WELWYN HATFIELD BOROUGH COUNCIL – DEVELOPMENT MANAGEMENT
DELEGATED REPORT

APPLICATION No: 6/2015/2334/HOUSE

SITE ADDRESS: 77 Eddington Crescent, Welwyn Garden City, AL7 4SX

DESCRIPTION OF DEVELOPMENT: Erection of rear orangery

Drawing Title: **PLANS AND ELEVATIONS
 AS PROPOSED**

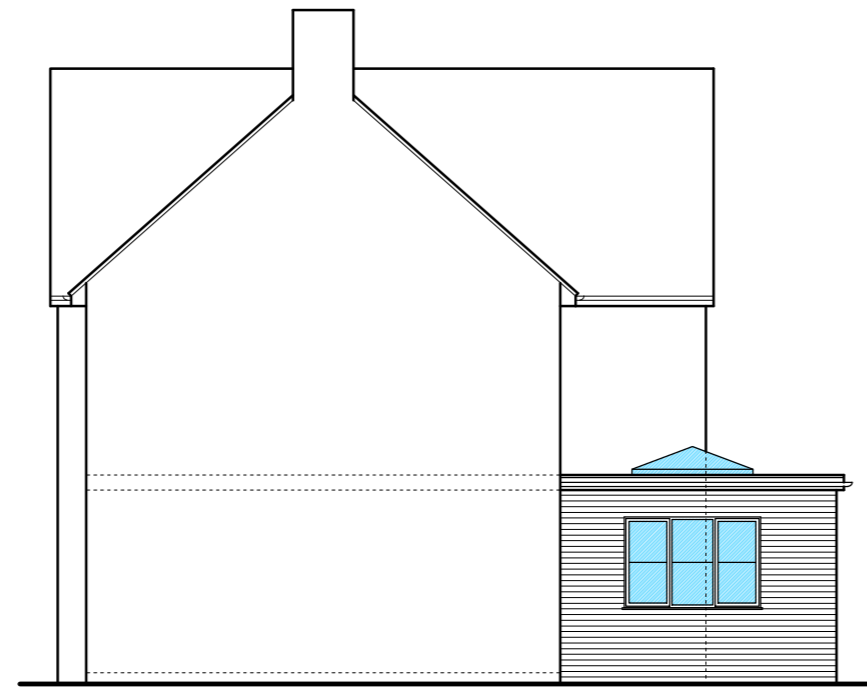
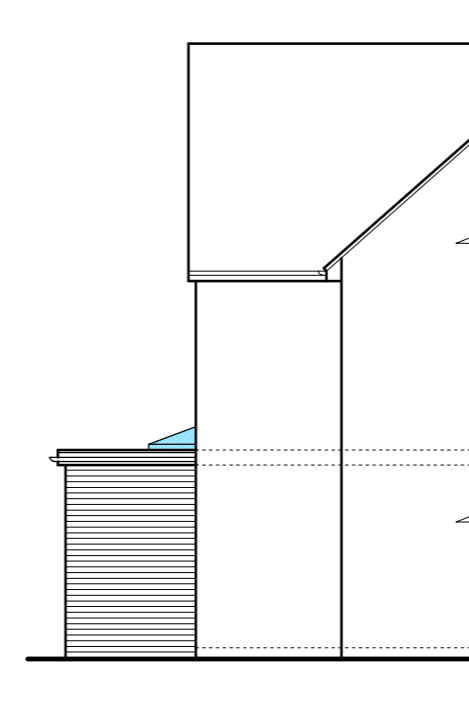
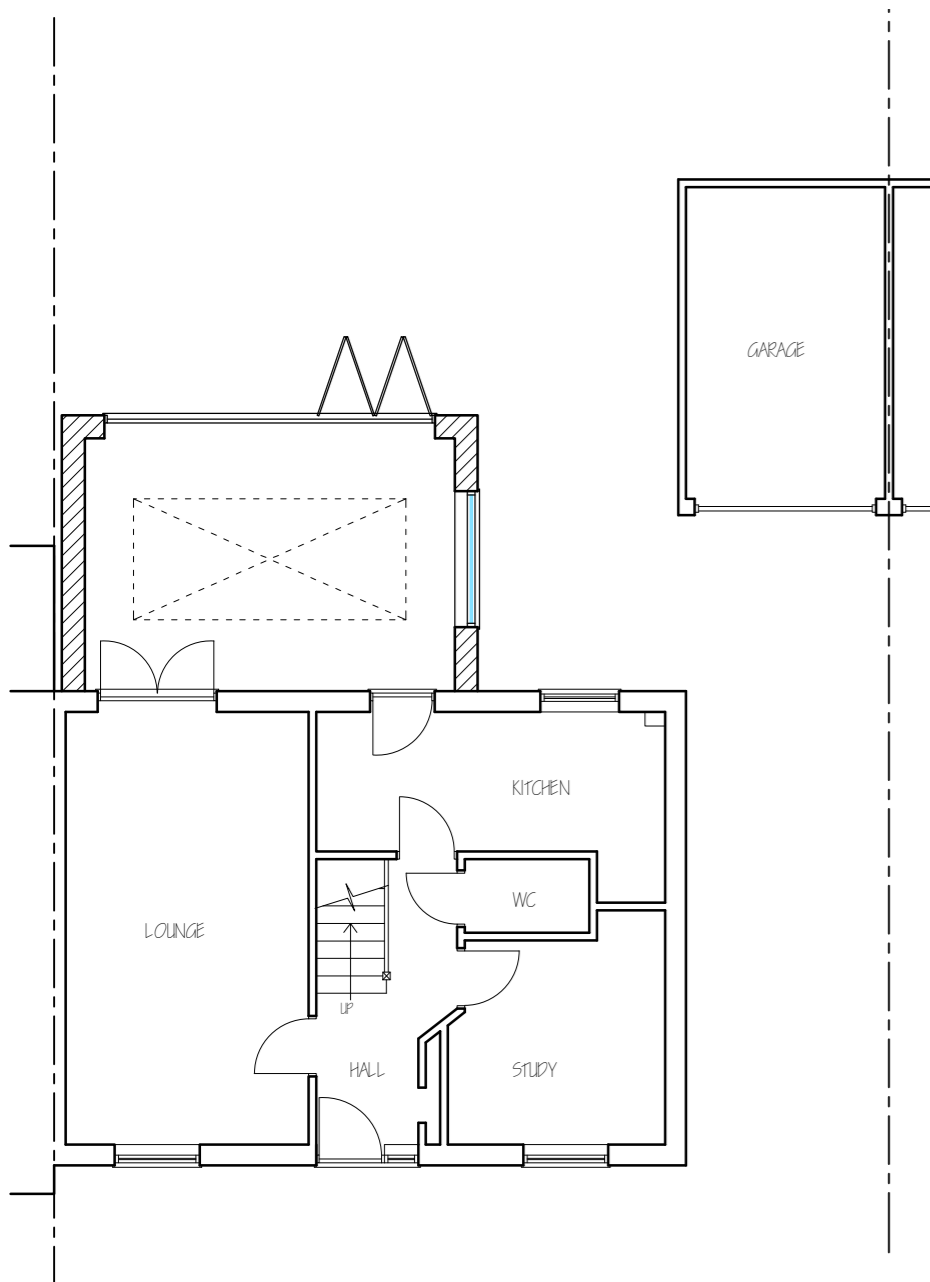
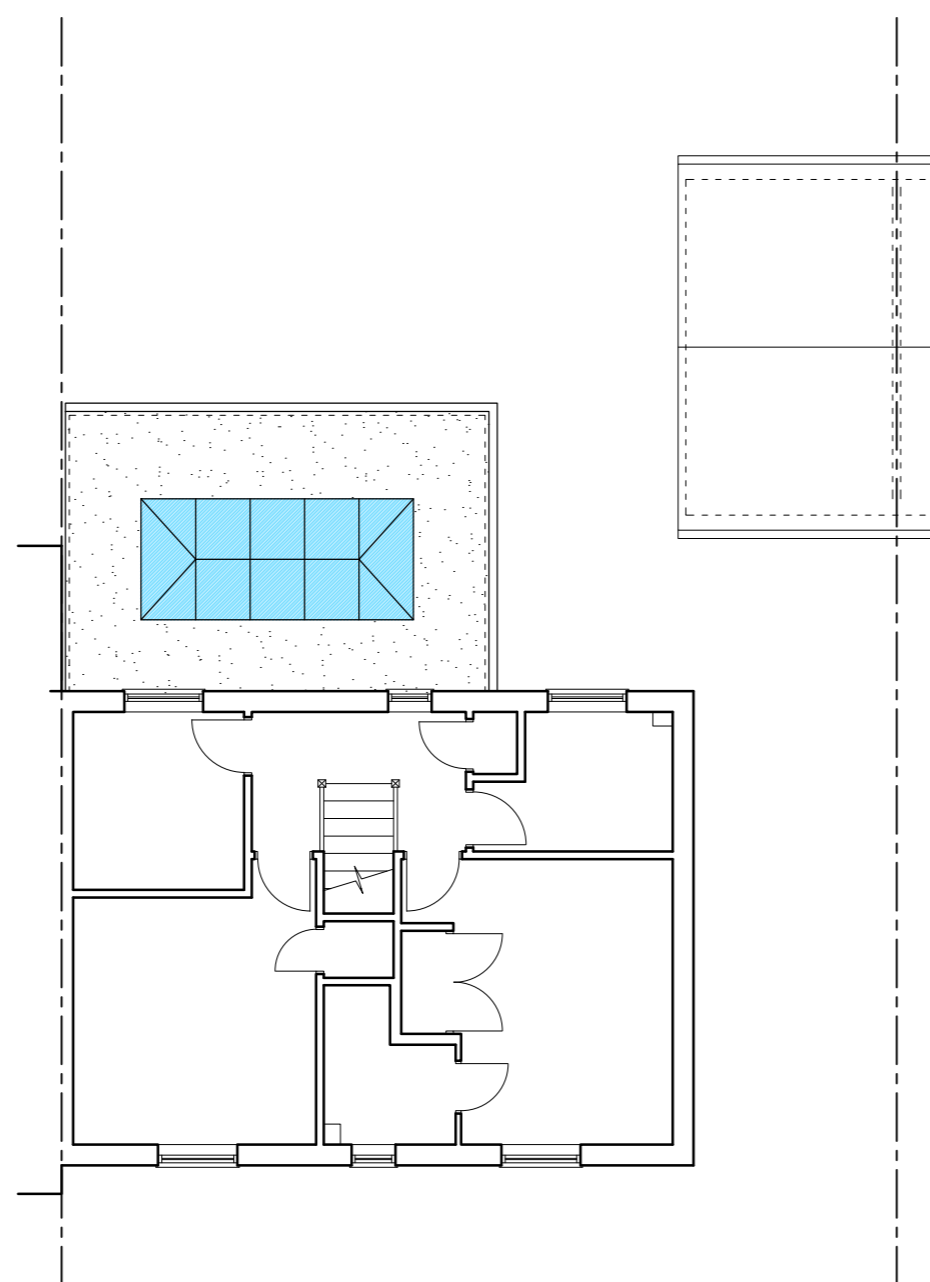
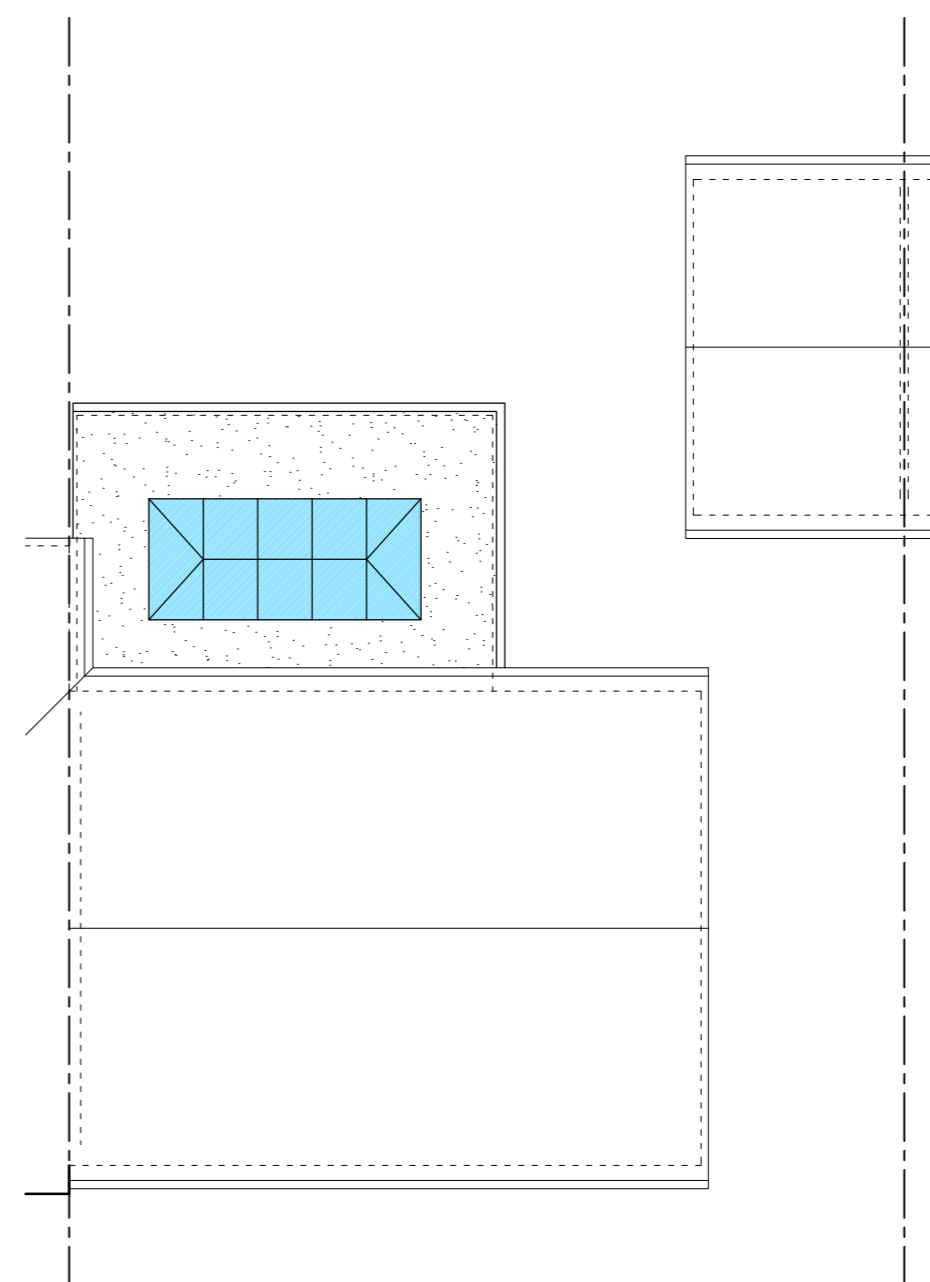
In this respect, the proposed rear extension is to be built up to the east boundary of the site and at a depth of 3.8m and a height of 2.8m, it is considered of a satisfactory design, size and form. No. 75 has no existing rear extensions but has a deeper rear building line to No. 77 of 1.85m. The windows to the proposed development are considered of a satisfactory design, alignment and siting, in proportion with the amount of brickwork and in character with the existing windows to the property.

The proposed extension is to be built up to the shared boundary with no. 75, the adjoining semi-detached dwelling that has no existing rear extensions. The rear flank of no. 75 projects 1.85m deeper than no. 77 and therefore at a depth of 3.8m and a height of 2.75m it is not considered that the proposed extension would result in any amenity implications in the form of a loss of light, outlook or over bearing impact.

The west flank of the proposed extension is set in 5.31m from the boundary of the site and would be obscured from public views to some extent by the existing high gable roof garage. The east flank of No. 79 is set in 4.7m from the west boundary of the application site and also has a side/rear garage built up to the applications site side garage. With a separation distance of some 10m between no. 79 and the proposed extension and that with two 1.8m high close boarded fences the proposal is not considered to result in any demonstrable harm to the amenity of no. 79 in the form of a loss of light or outlook.
